ENG-PUDSP22001-R1-TIS.pdf Markup Summary

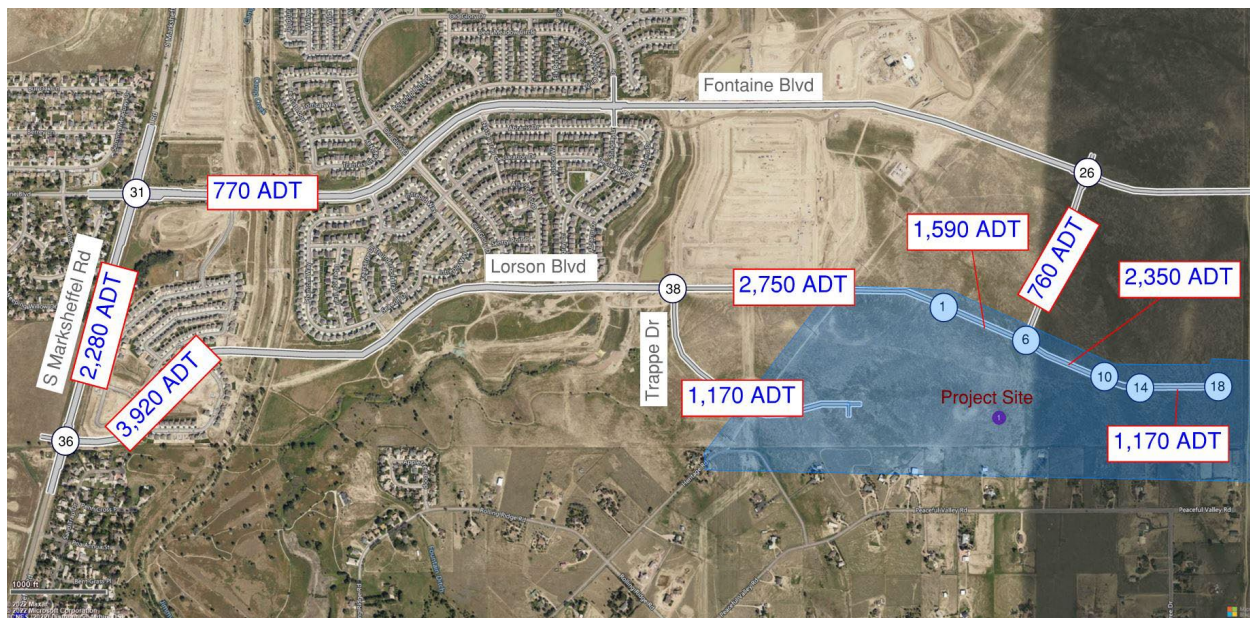
Show internal distributions on Fontaine and Lorson also

Figure 11. Build Out Background Traffic Volumes (AM Peak Hour)

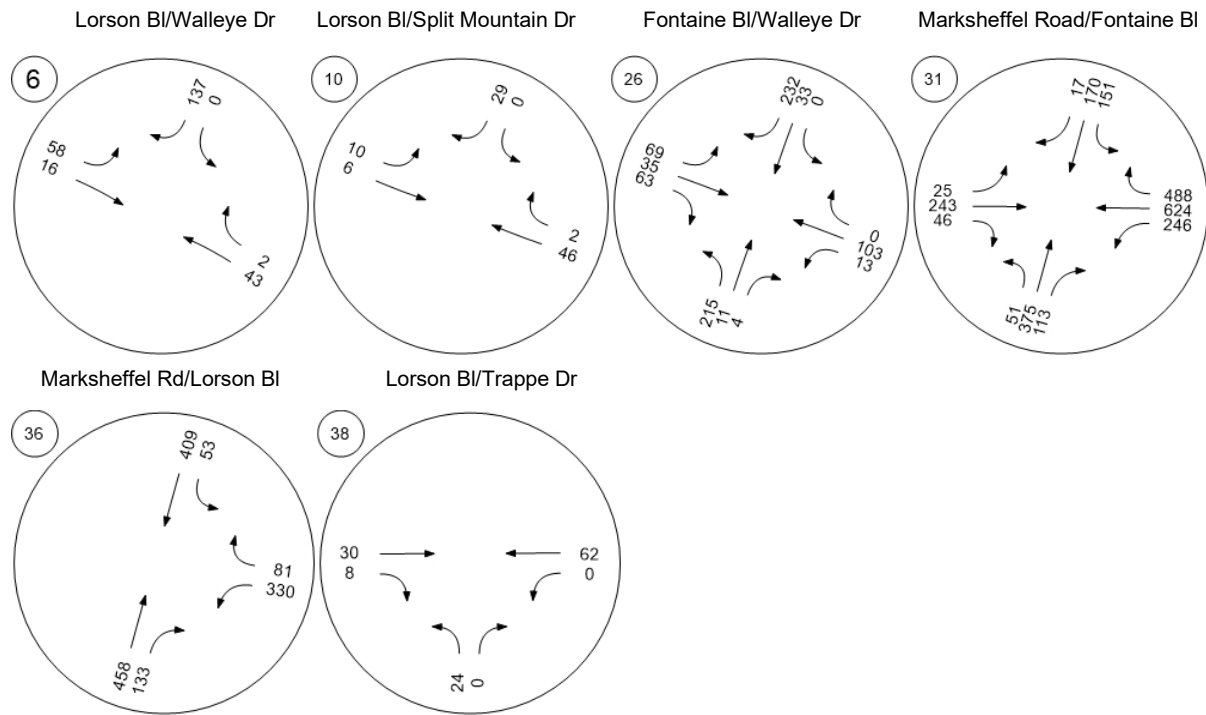
Label major street names

Figure 12. Build Out Background Traffic Volumes (PM Peak Hour)

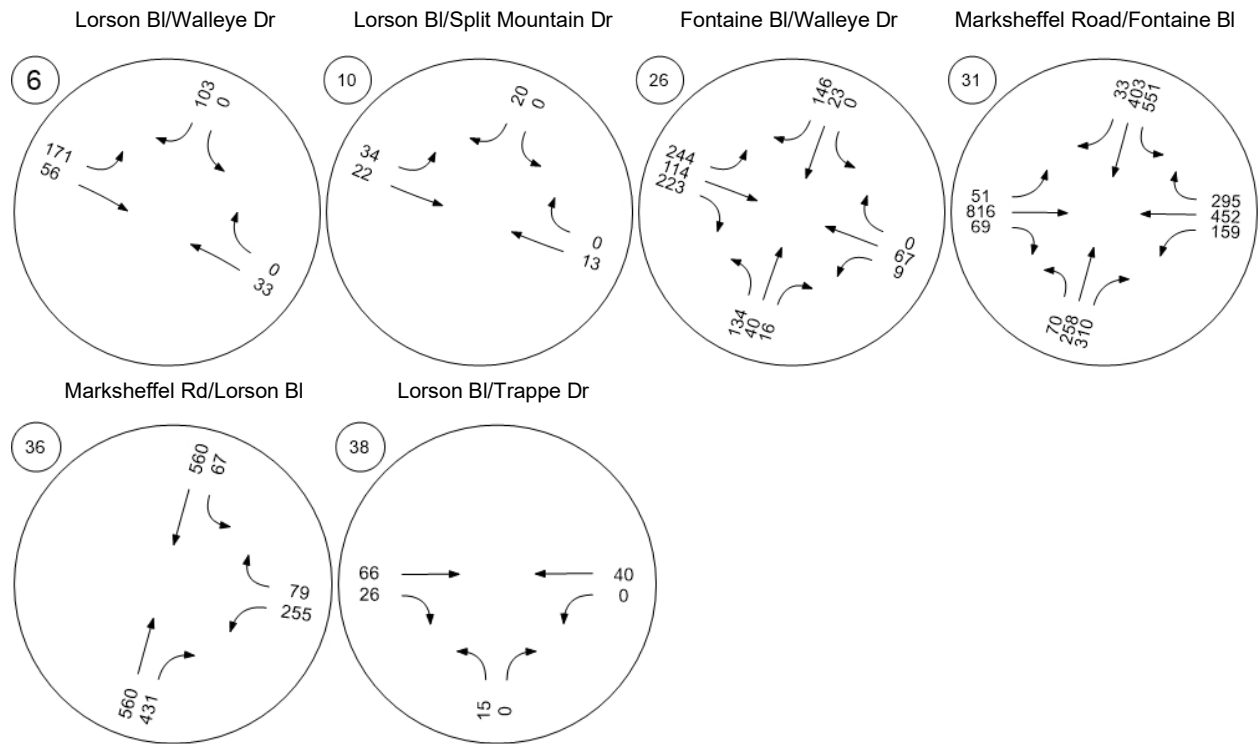
Label street names

Figure 15. Build Out Total Traffic Volumes (AM Peak Hour)

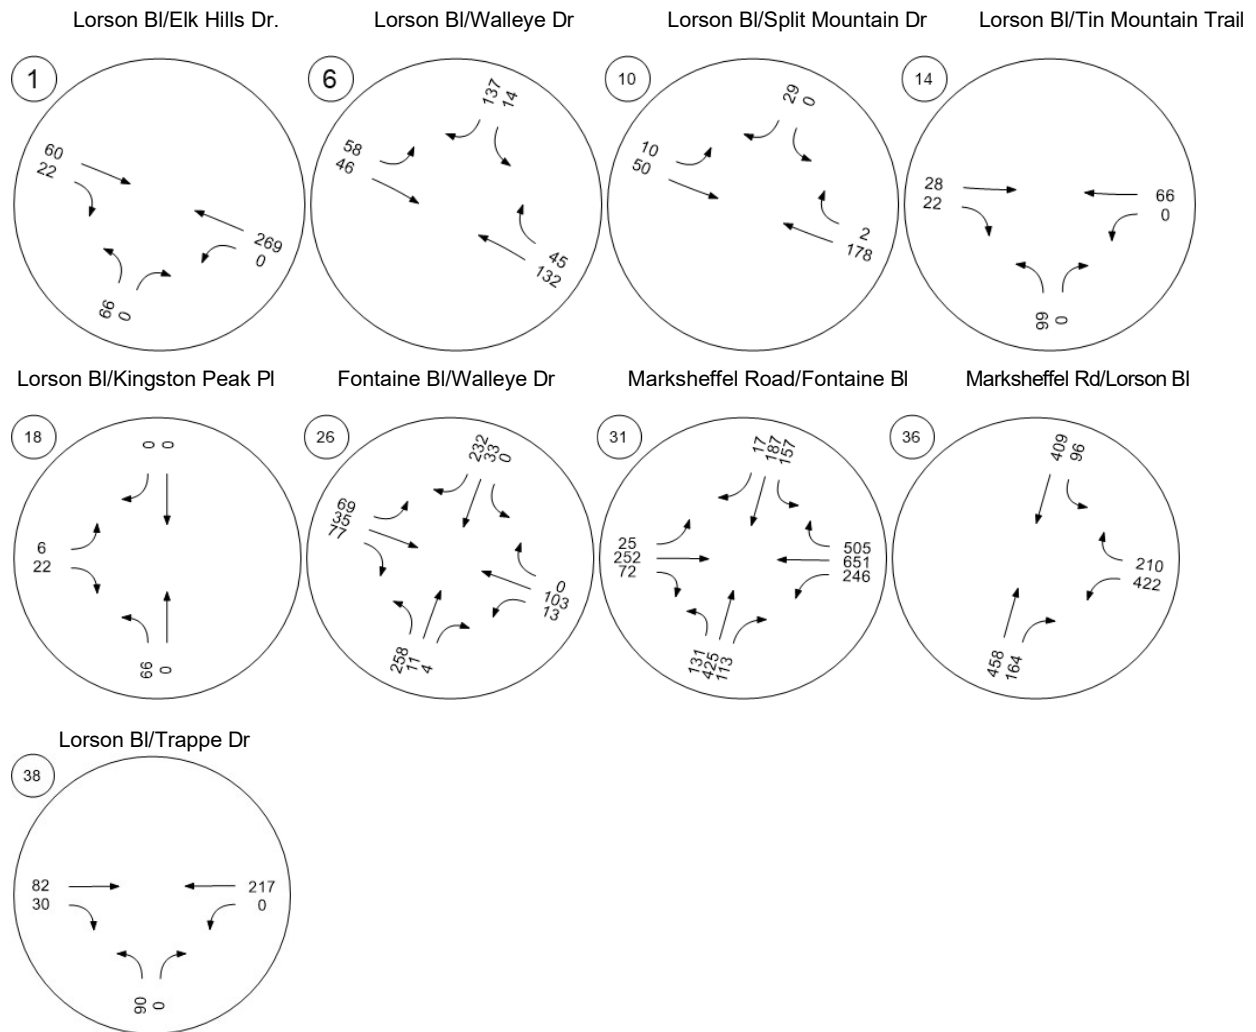
Label major street names

**Figure 16. Build Out Total Traffic Volumes (PM Peak Hour)**

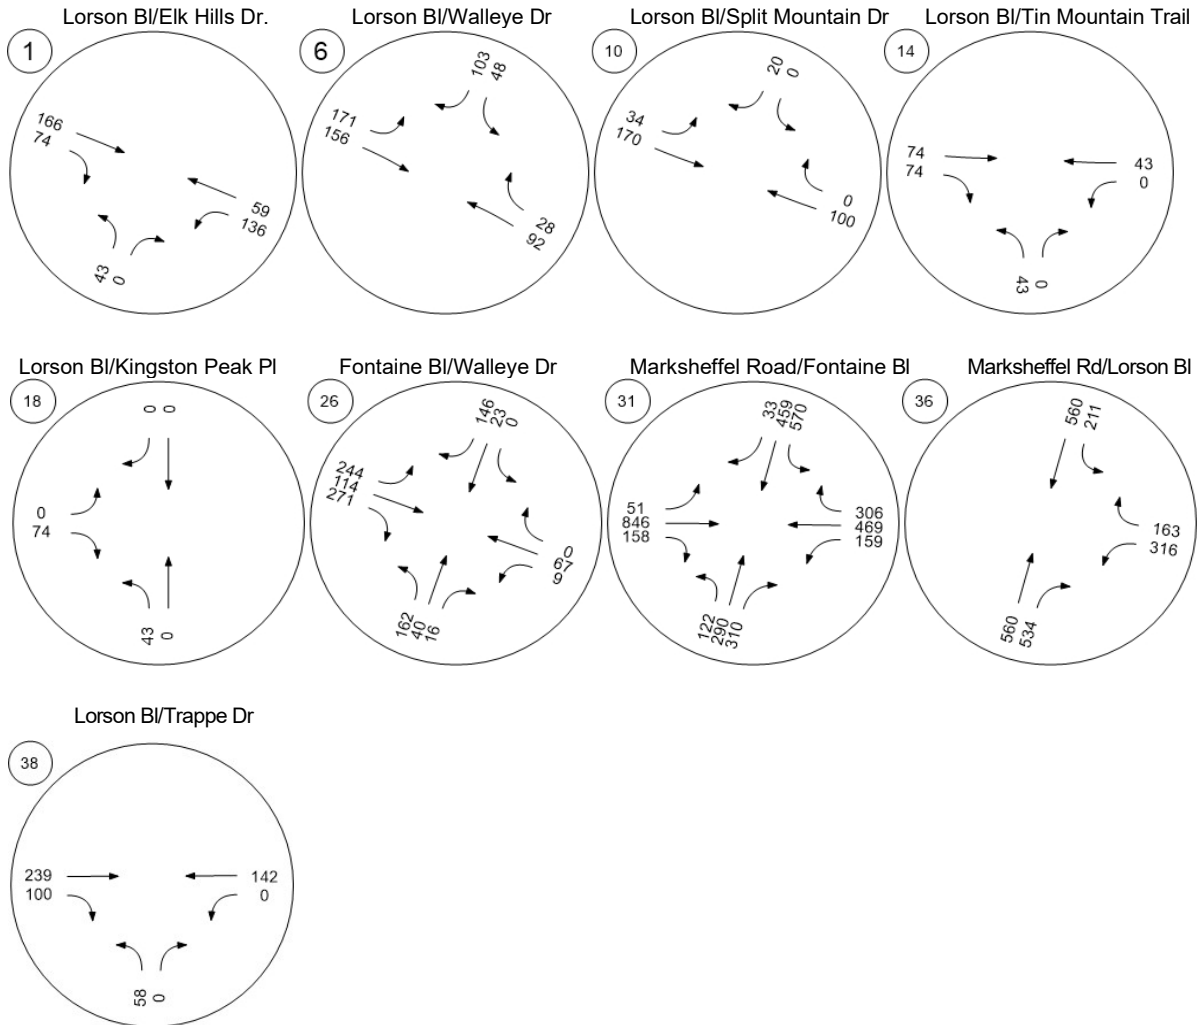
Label major street names
